8 February 2017

CR2016/005578
SF2014/151868
CM

NELSON BAY ROAD (B63): SECTION 75W MODIFICATION OF THE FERN BAY RESIDENTIAL ESTATE, SEASIDE BOULEVARDE, FERN BAY (MP 06_0250 MOD 8)

DRAWING TITLE
STAGING & LOT LAYOUT REV-1
PROJECT PLAN L
FERN BAY SEASIDE VILLAGE
NELSON BAY ROAD, FERN BAY
CLIENT
RAWSON COMMUNITIES PTY LIMITED

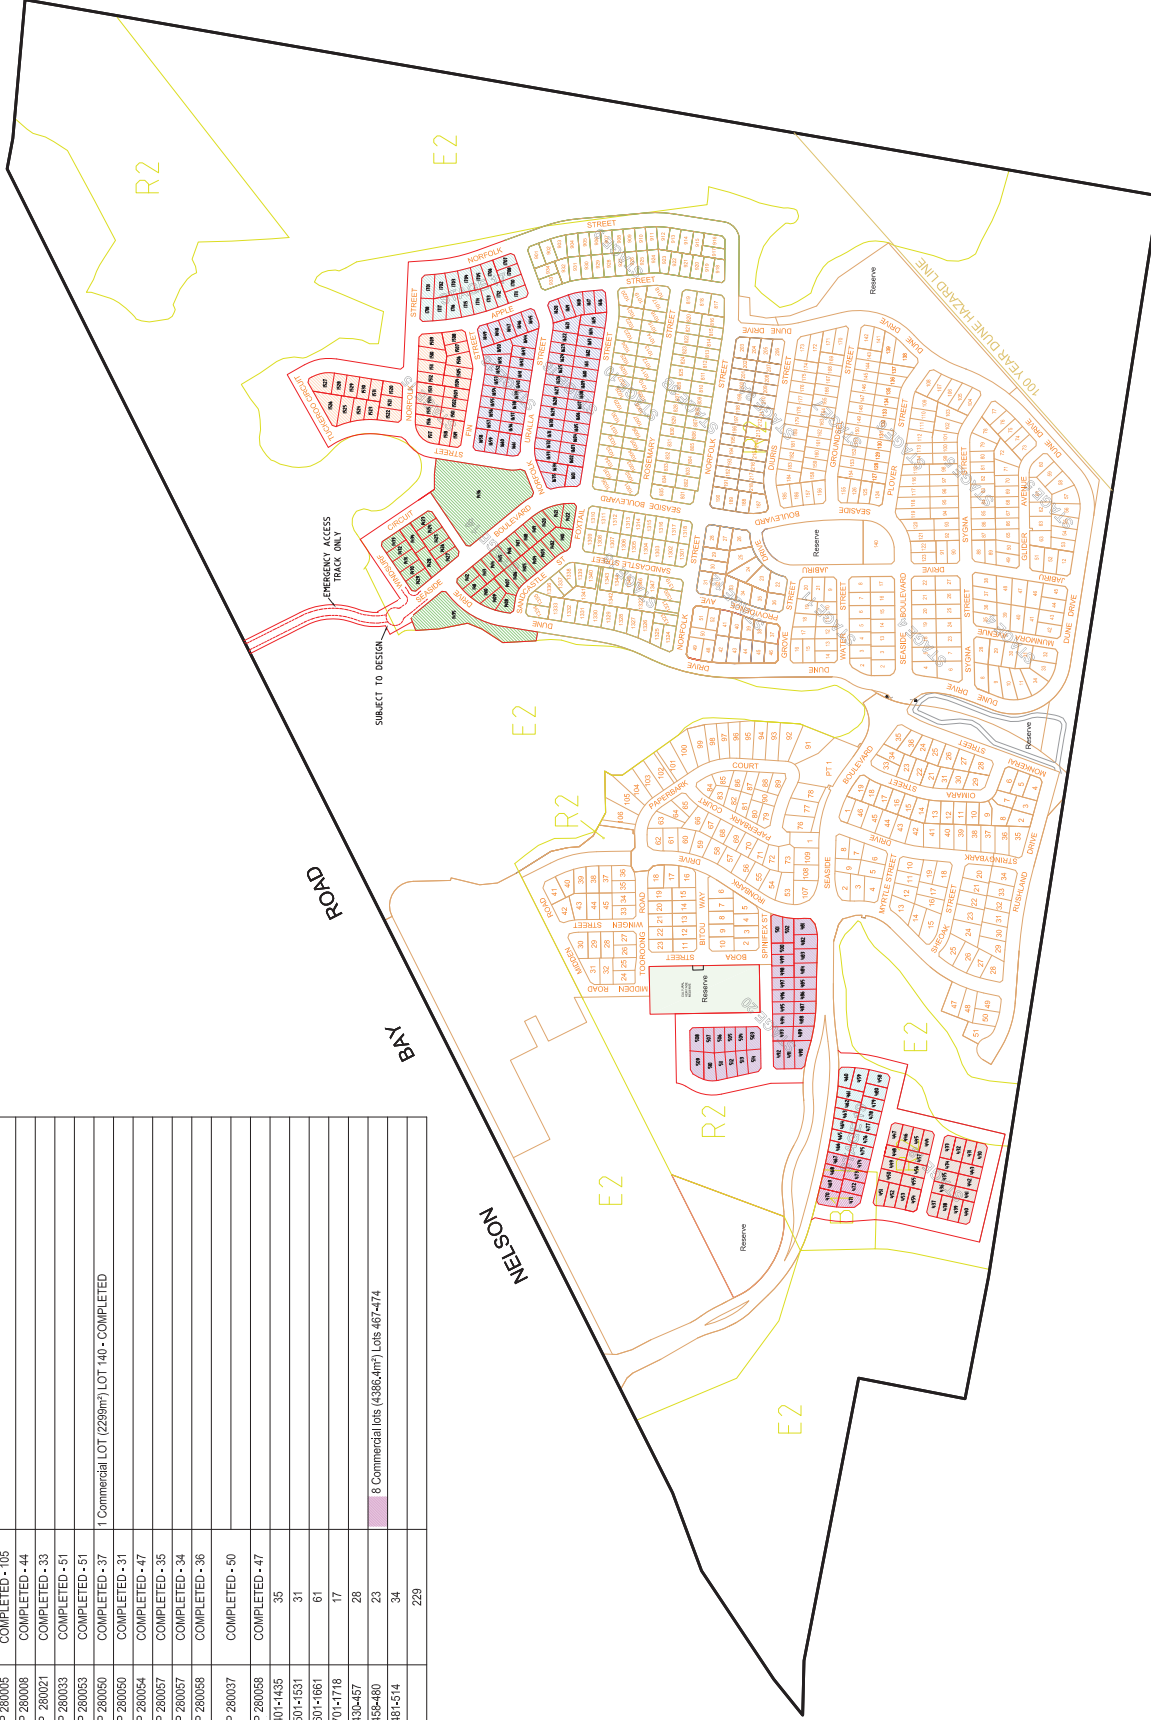
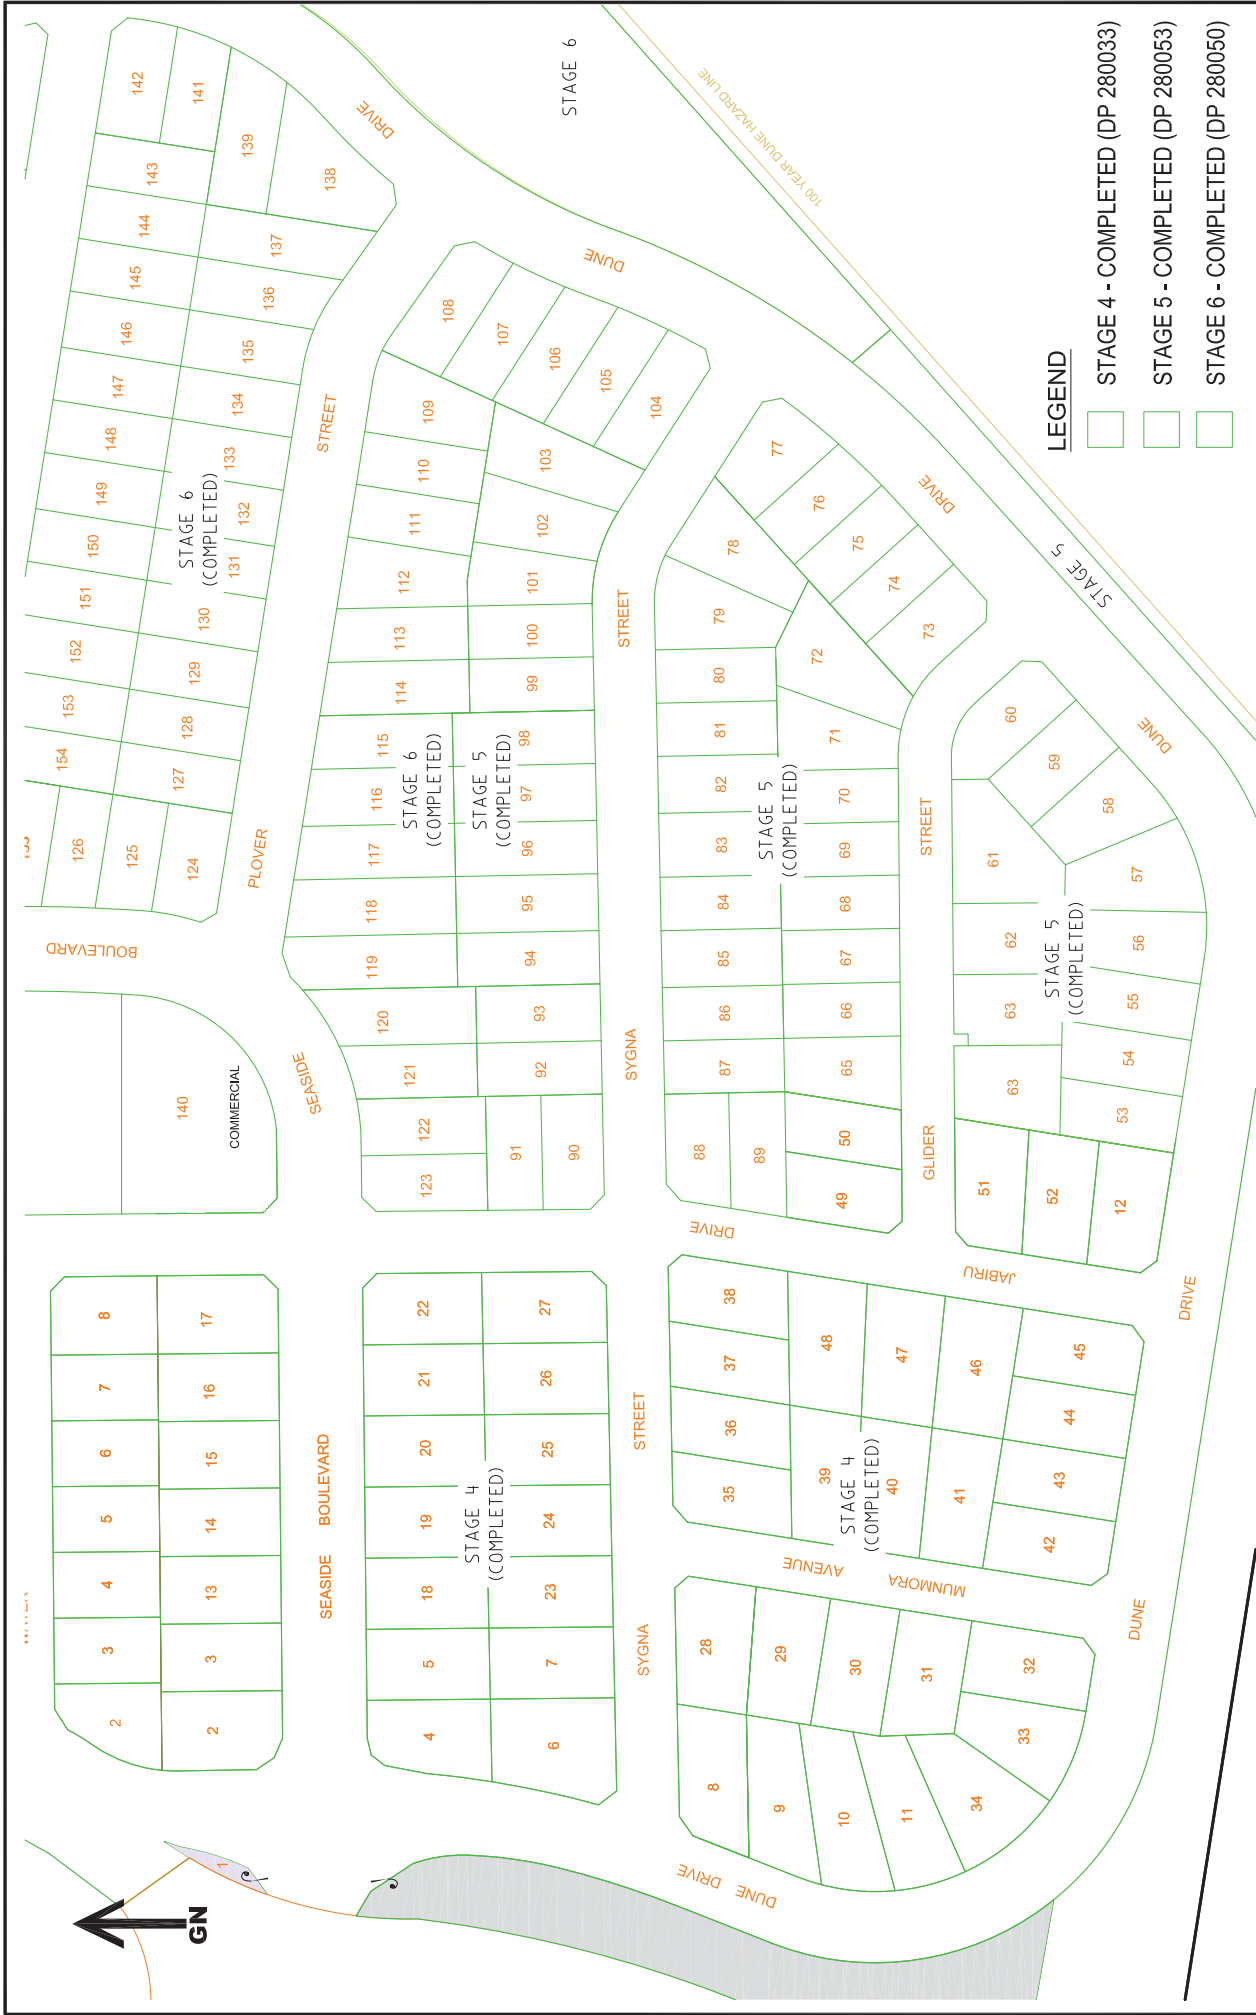
connection to Nelson Bay Road was not a requirement recommended to be imposed by Roads and Maritime. It is understood that the single access was part of the original master plan for the subdivision. The Department should confirm that the additional access is not required in accordance with the original urban design requirements as part of the master plan.

- The traffic report from Intersect Traffic consultant shows the intersection at the Seaside Boulevard and Nelson Bay Road has the capacity to cater with the traffic growth generated from the full development.
- The reconfiguration of the layout in Stages 18, 19 and 20 has no additional impact on the traffic volumes around the internal network

On this basis, Roads and Maritime raises no objection to the proposed modification application as it is considered there will be no significant impact on the nearby classified (State) road network.
